HUHN, KEN, 3/7/2024 6:37 AM

GRANDVIEW RESERVE PHASE 2 PUD DEVELOPMENT PLAN & PRELIMINARY PLAN

NOT FOR CONSTRUCTION
 LAND USE REVIEW FILE NO: PUDSP-23-006

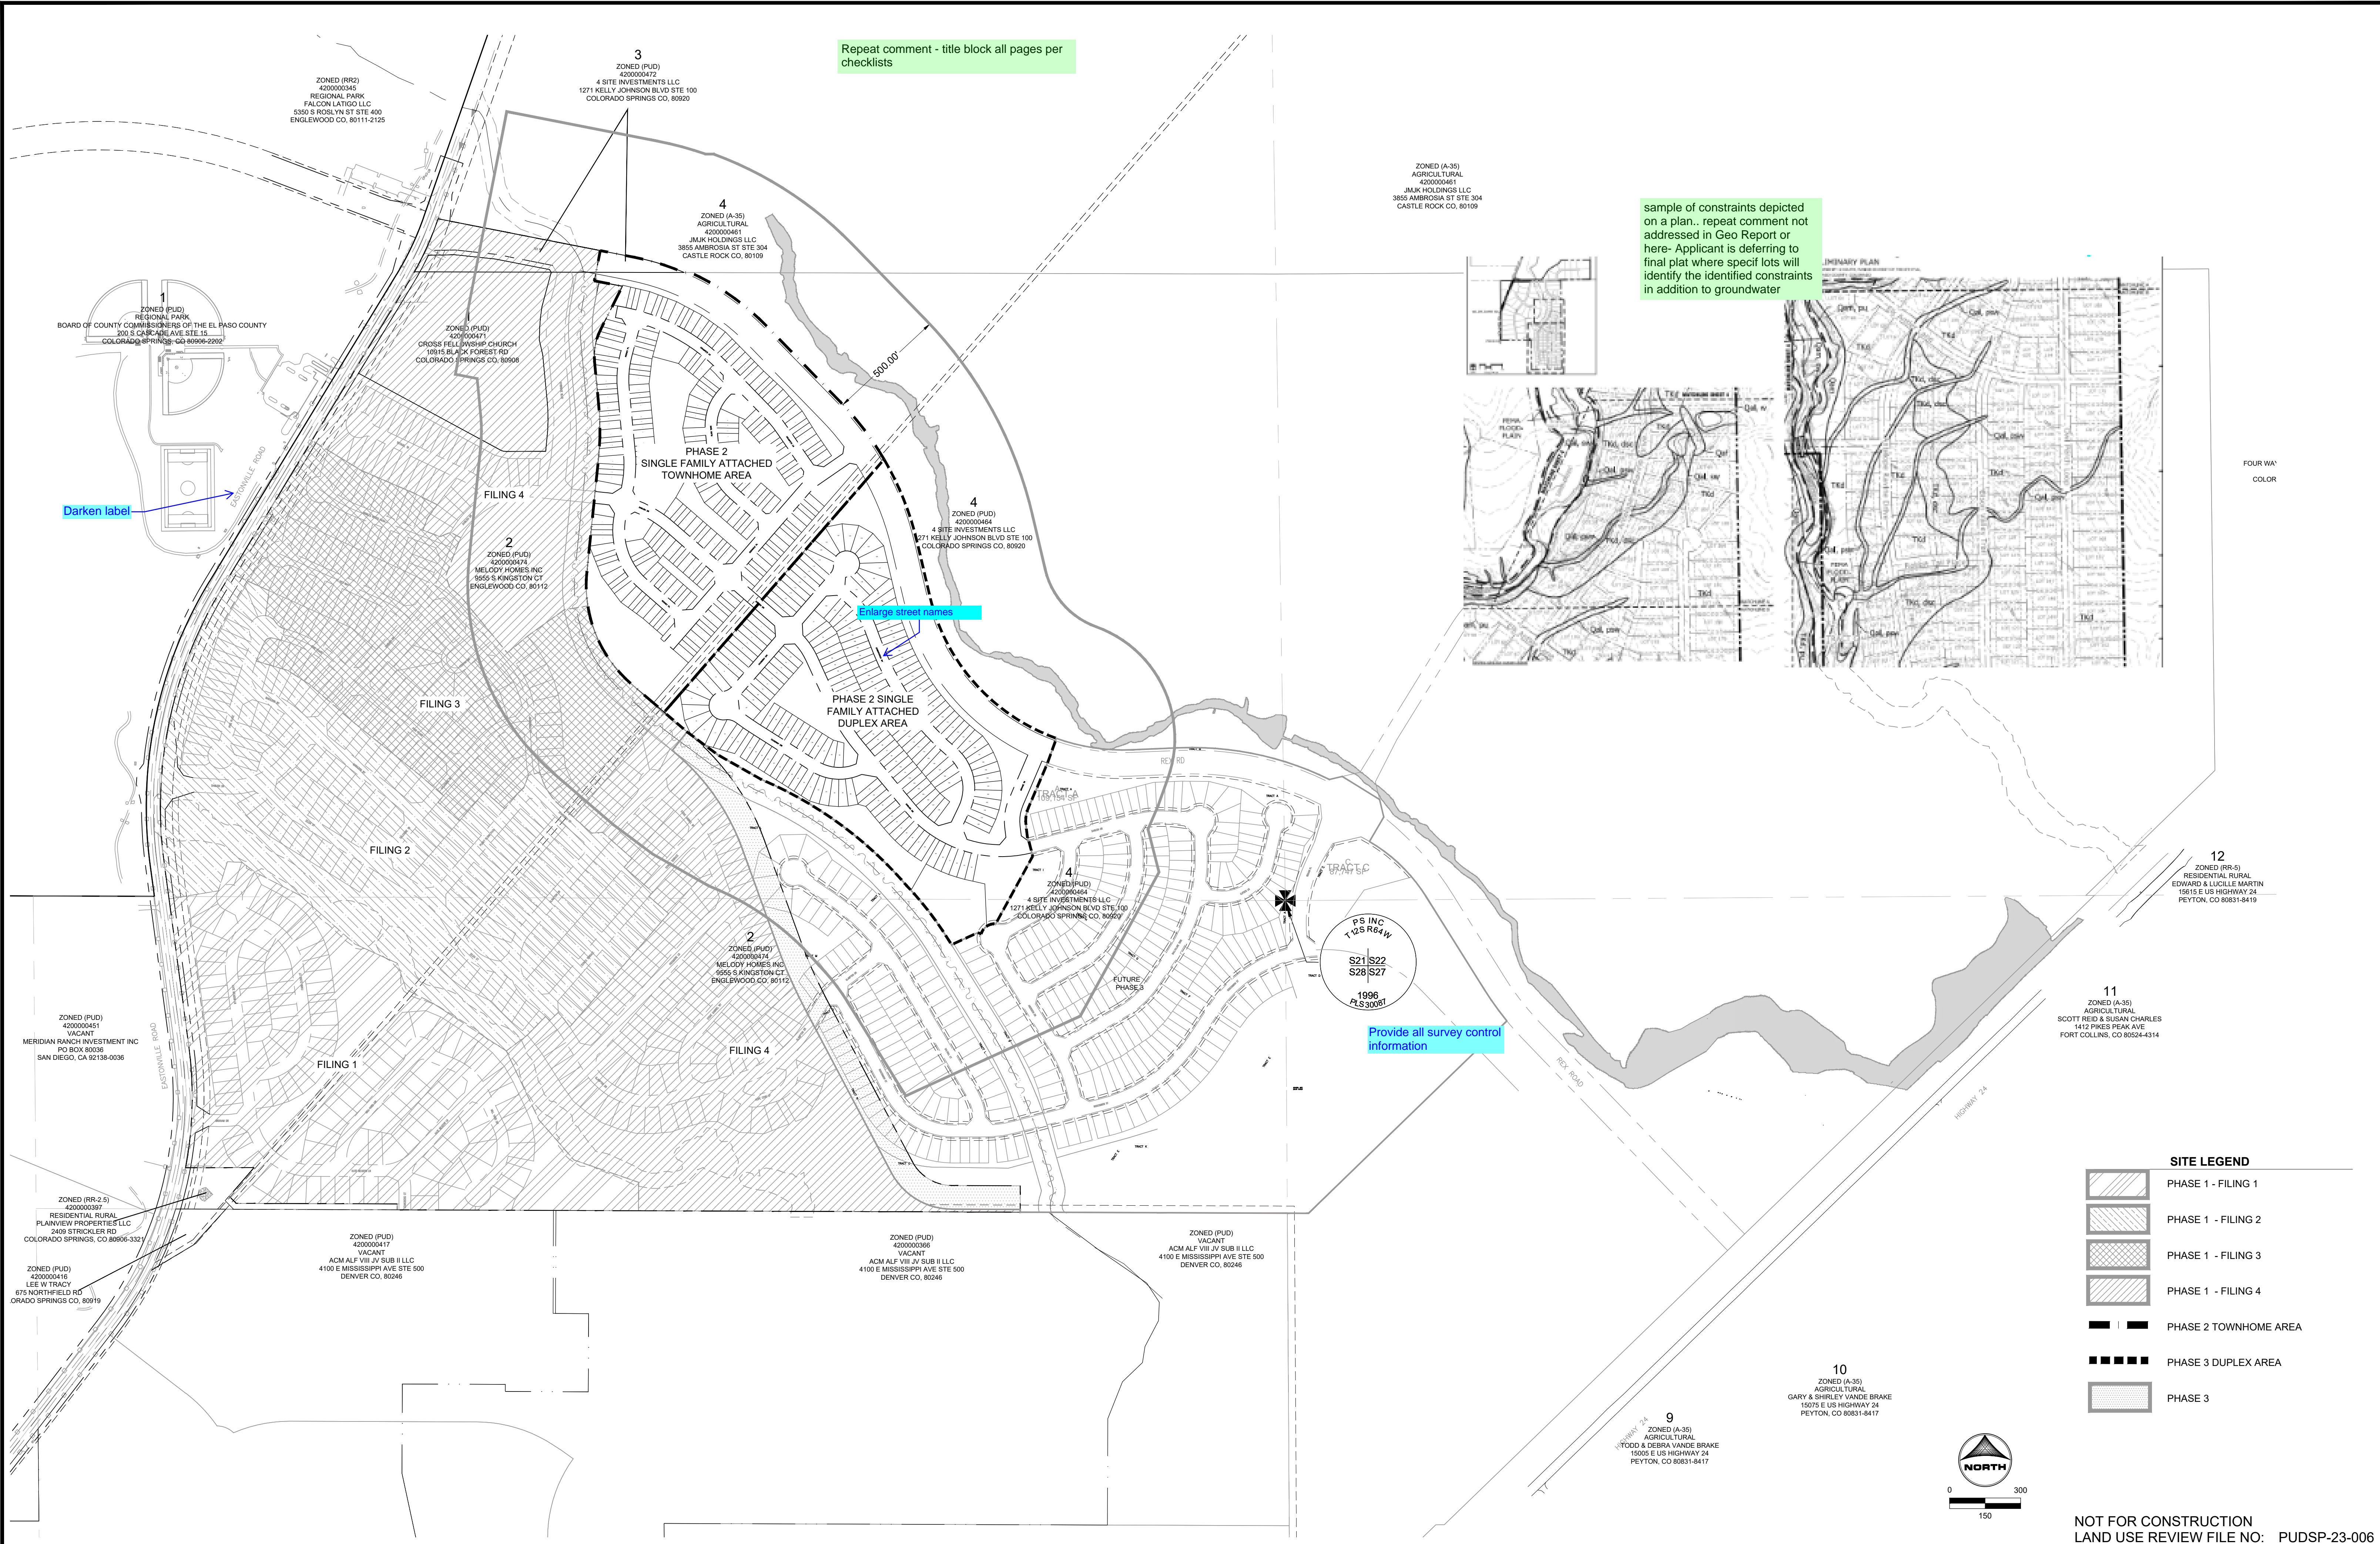
i thought this was going to be converted to usable openspace with the trail which would bring the usable open space up to exceed standrds

Are there lift stations, tanks, pump stations here? where are they? Please label as utility (Tank site- lift station site- Pump station site) tract.

utility lines are very different from structures like Tanks, pump station; treatment facilities, etc; these should be clearly labeled on map to left if within this development; lot owners need to be aware what they are adj to

HIRG RESPONSE:
NOTED, THE ONLY KNOW STRUCTURE PLANNED IS A FUTURE TANK WHICH HAS BEEN IDENTIFIED, SINCE THE INITIAL TANK NEEDED FOR GRANDVIEW IS NOW LOCATED IN PHASE 1 WE DID NOT INCLUDE THIS TRACT AS PART OF PHASE 2. WE IDENTIFIED THIS AS A POTENTIAL LOCATION FOR A FUTURE SECOND TANK IF NEEDED.

HIRG RESPONSE:
THE USABLE OPEN SPACE HAS BEEN DEFINED ON THE NEW SITE PLAN.

HIRG RESPONSE:
FUTURE WATER TANK SHOWN AND CALLED OUT, NO ADDITIONAL INFRASTRUCTURE IS PLANNED WITHIN THE VICINITY OF PHASE 2

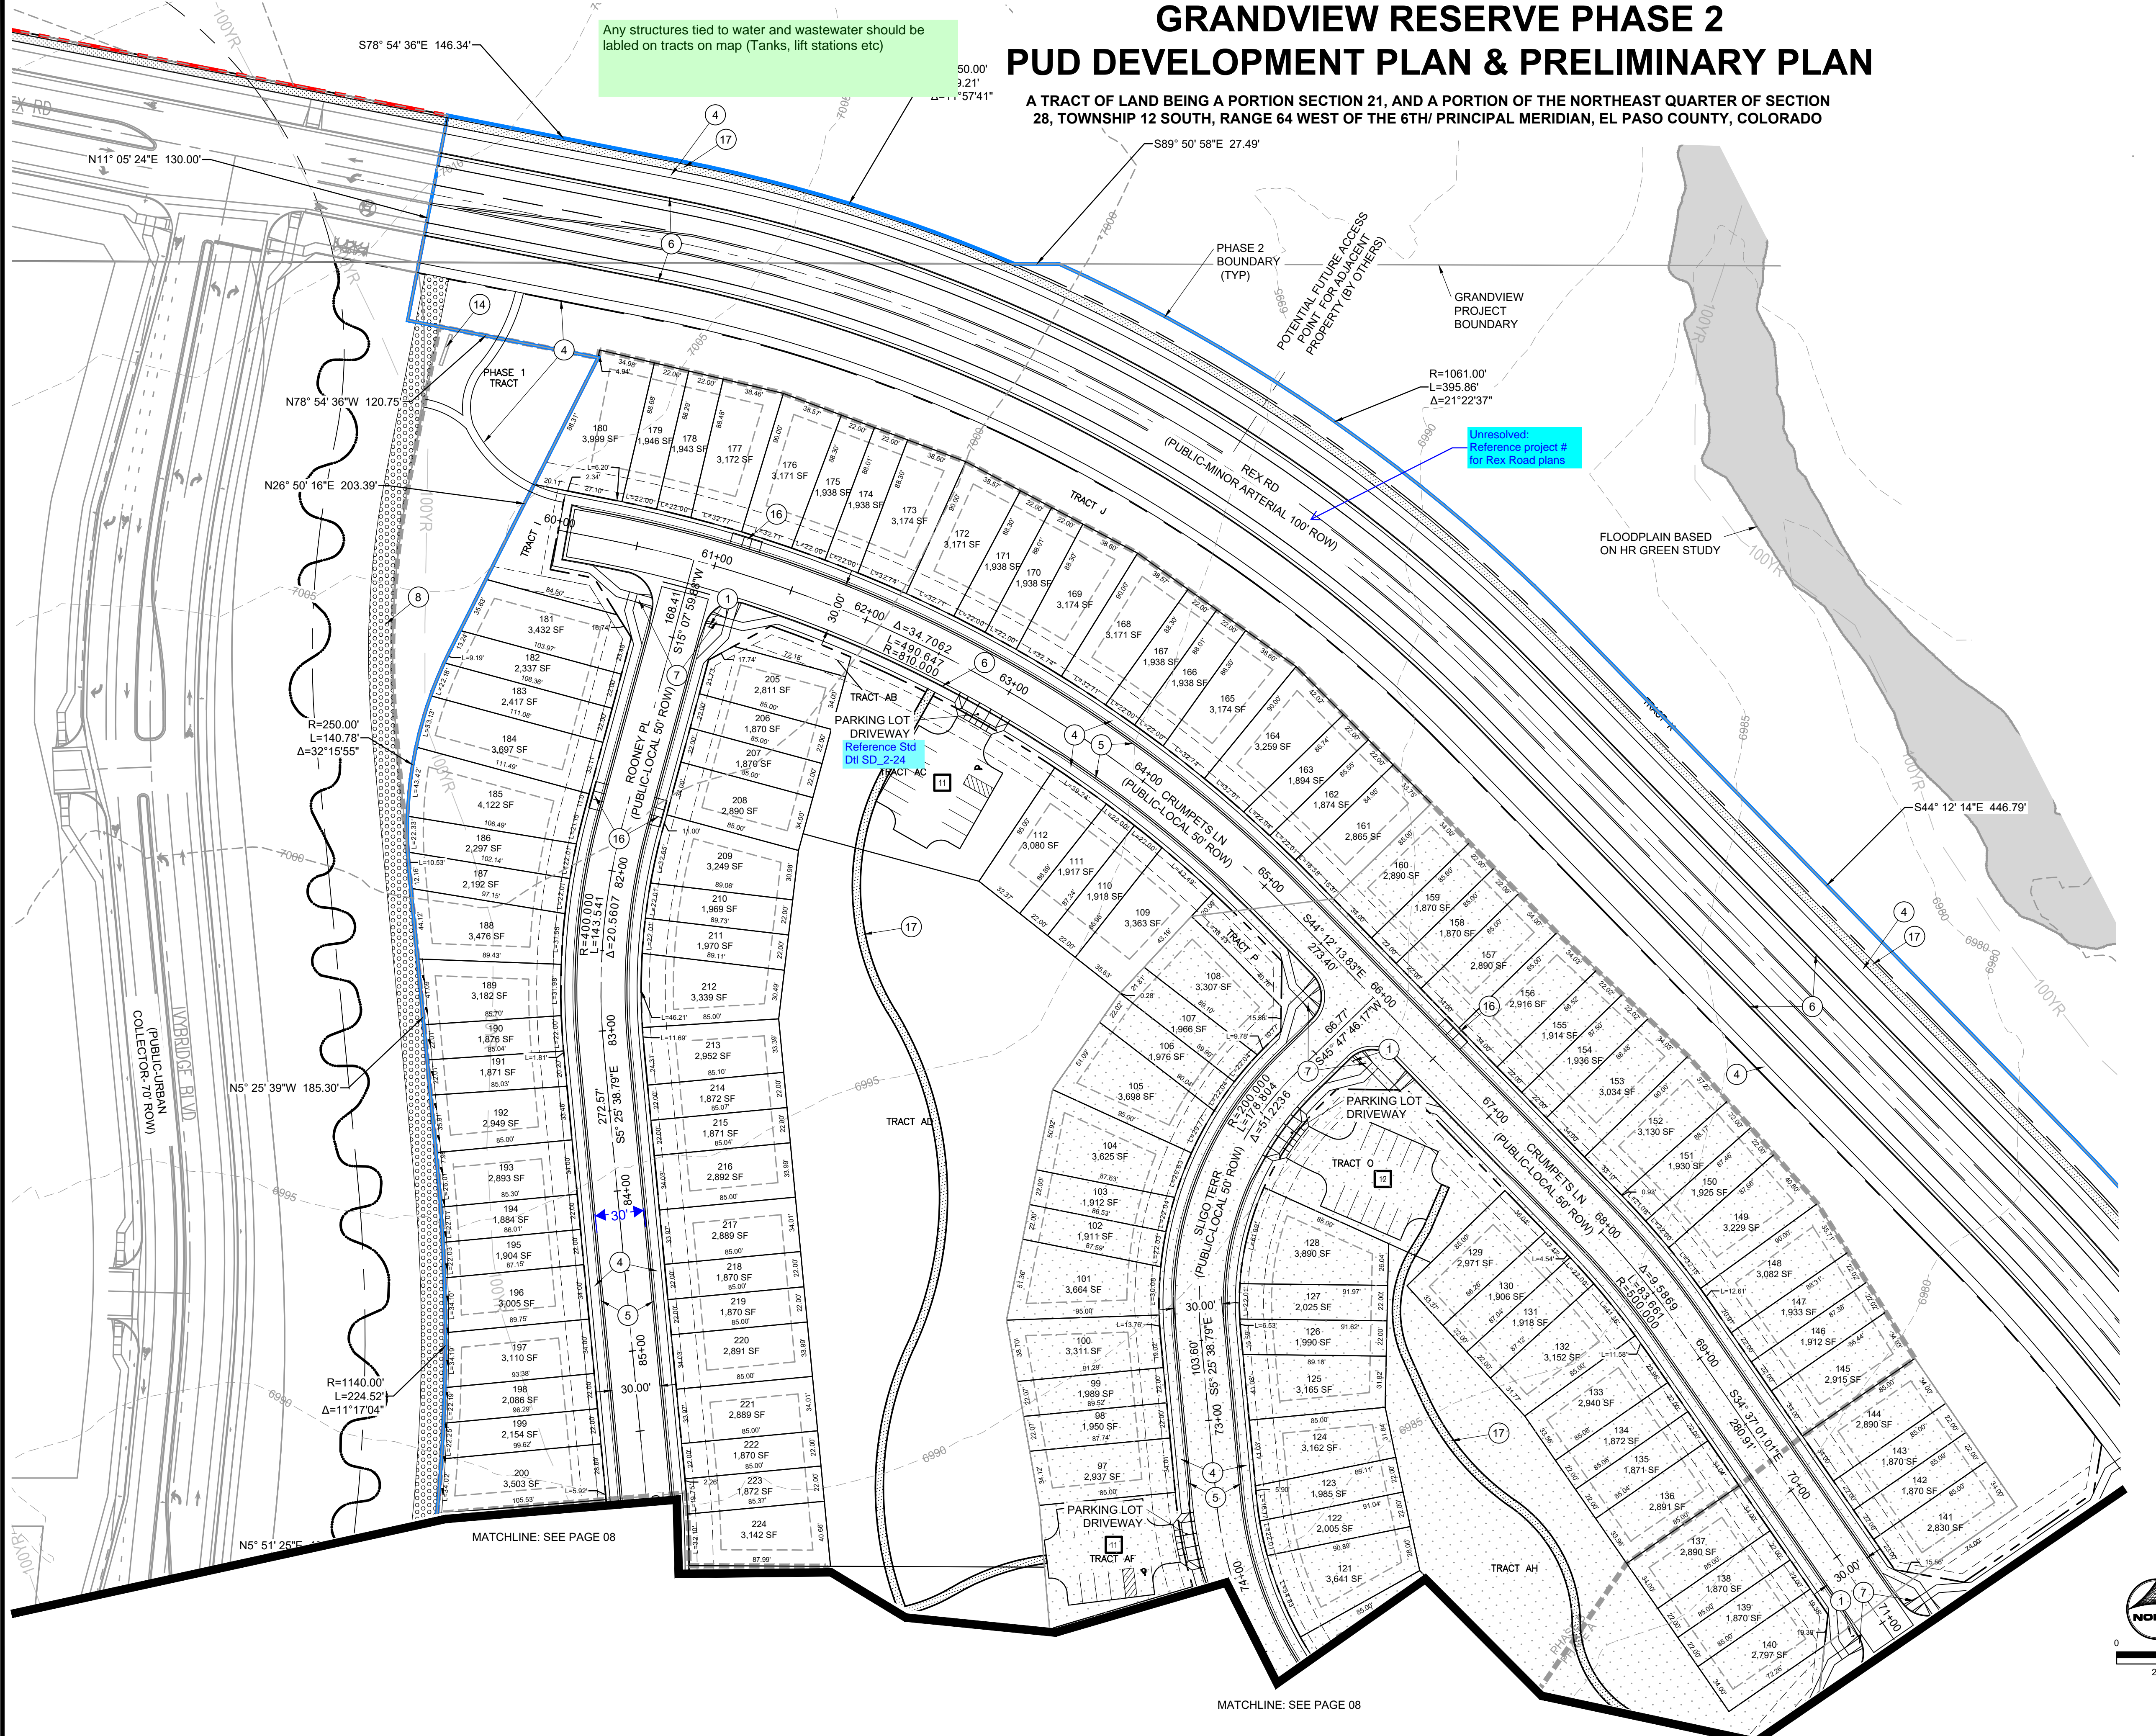
Any structures tied to water and wastewater should be labeled on tracts on map (Tanks, lift stations etc)

Unresolved: Reference project # for Rex Road plans

Reference Sid Dtl SD 2-24

darken hatch all sheets in legend not legible when printed

there are areas where ground water is less than 5 feet 3 feet and crawlspaces likely not feasible

HRG RESPONSE: WATER STORAGE TANK SHOWN ON TRACT PLAN AND CALLED OUT

HRG RESPONSE: REX ROAD IS A PART OF THIS PROJECT

HRG RESPONSE: DETAIL REFERENCED

HRG RESPONSE: (BASED ON THE LATEST GRADING PLAN AND UPDATED FIGURE 3 MAP) ONLY THE FOLLOWING LOTS ARE WITHIN THE 0-5' RANGE: TOWNHOME LOTS 73-76 DUPLEX LOTS 47-50 AS NOTED IN THE GEOHAZARD REPORT (PAGE 9) THE USE OF A SLAB ON GRADE FOUNDATION CAN BE UTILIZED. THE LOTS HAVE BEEN IDENTIFIED ON THE PLAN AND REFERENCED TO THE SLAB FOUNDATION HAS BEEN ADDED TO THE LEGEND
